Technical Memorandum

Date: 7 September 2017
Project: 908157-03000

**Re: Southminster Church – 1040 Bank Street
Residential Development – Parking Review**

Figure 1: Existing On-Site and On-Street Parking

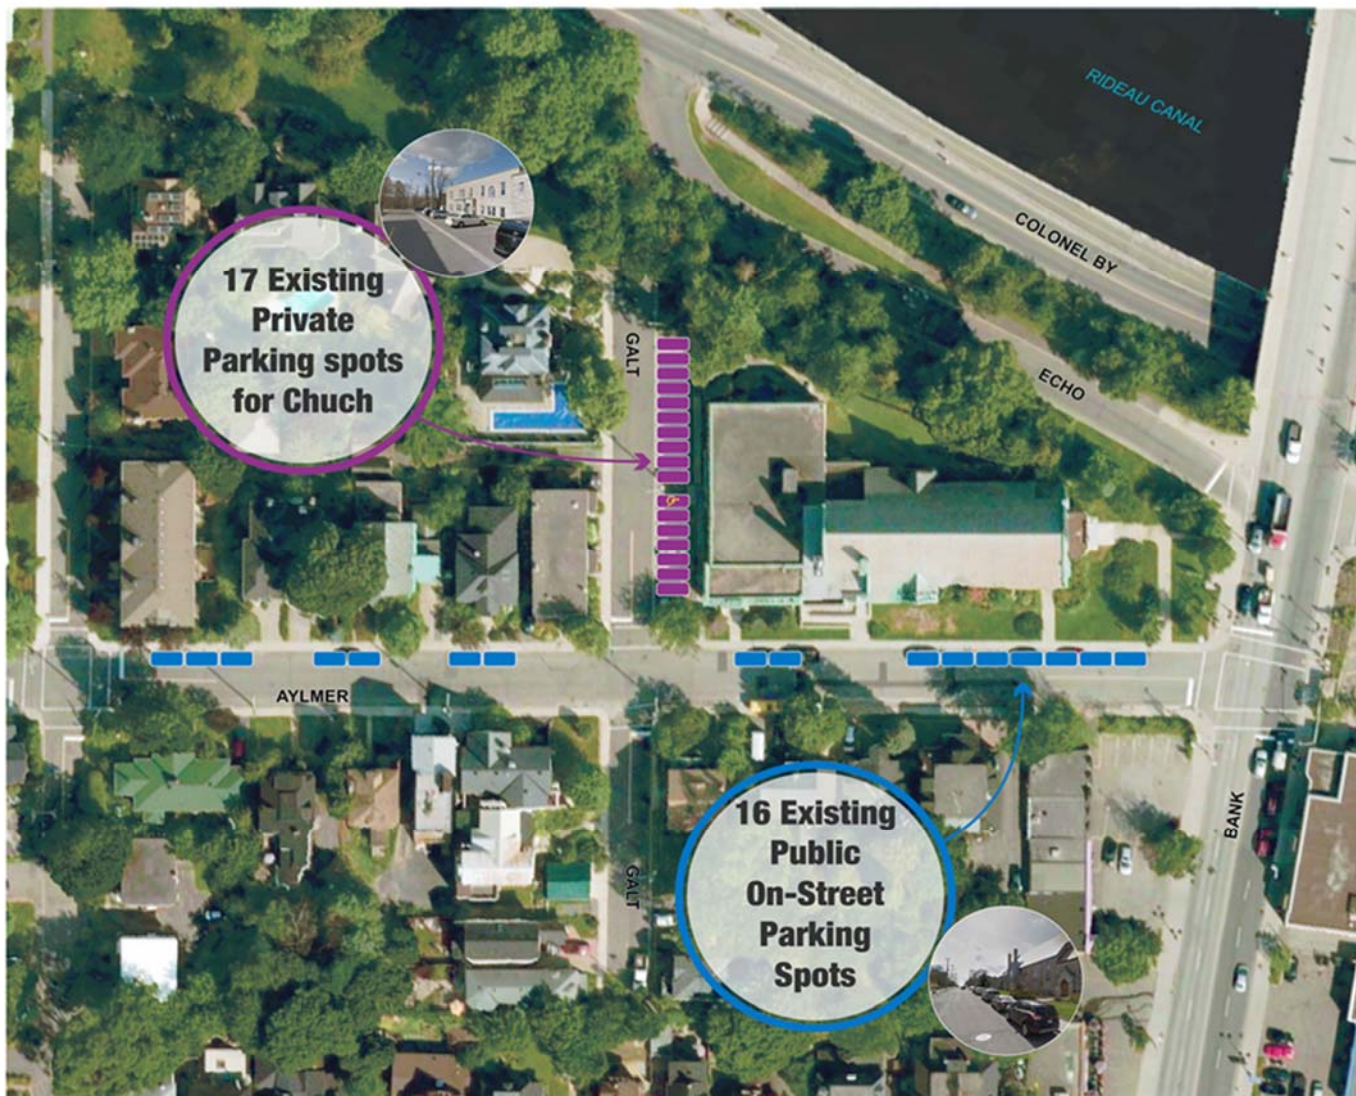
Comment 12: Please provide a parking study prepared by a qualified professional assessing supply and demand for on-street parking within the surrounding neighbourhood (approximately 400 metres).

Response 12: Based on a preliminary assessment of the area, within a 450 m walking distance from the site, there are approximately 121 existing on-street parking spaces. This is outlined in Table 1 below. The 17 private parking spaces on the subject site are not included in this count.

The planned increase in on-street parking is 7 spaces along Galt Street, for a total of 128 public on-street parking spaces within the vicinity of the church. Assuming church staff/members will use the proposed 7 on-street parking spaces along Galt Street, the increase demand for on-street parking in the neighborhood would be 10 additional vehicles or less (i.e. 7 planned public parking spaces to be added - 17 private parking spaces to be removed = -10 net difference of vehicle parking in the area).

A parking study showing occupancy of on-street parking spaces will likely not provide any additional information and the future operations of parking for church and other events at the subject site will be similar to the existing condition, as there is an increase parking demand of 10 vehicles (or less).

Figure 2: Proposed On-Site and On-Street Parking – Net Gain of 7 Public On-Street Parking

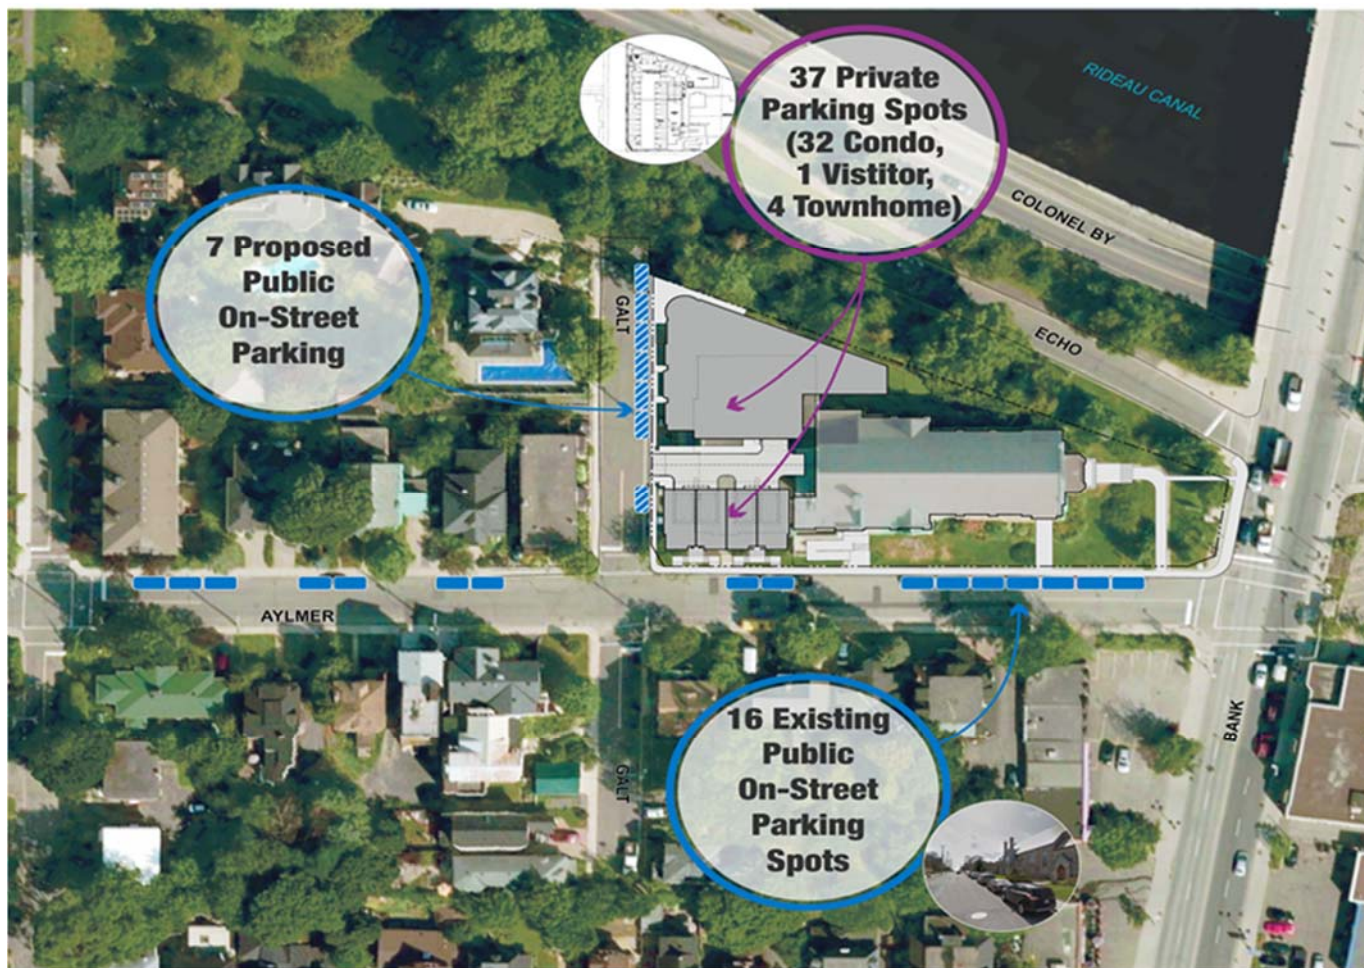
Comment 13: Please also provide a plan showing the proposed on-street parking configuration spaces along Galt Street and Aylmer Avenue.

Response 13: Please see Figure 2. A more detailed plan can be provided during the Site Plan Application stage and an RMA will be submitted if/when required. The estimated 7 parking spaces take into account the location of the proposed site driveway, the appropriate offset between parking and Aylmer Avenue, and the location of the MUP and fire hydrant at the north end of Galt Street. We are advised that the width required to implement on-street parking along a City roadway is 6 m of asphalt (minimum), which is currently provided along Galt Street.
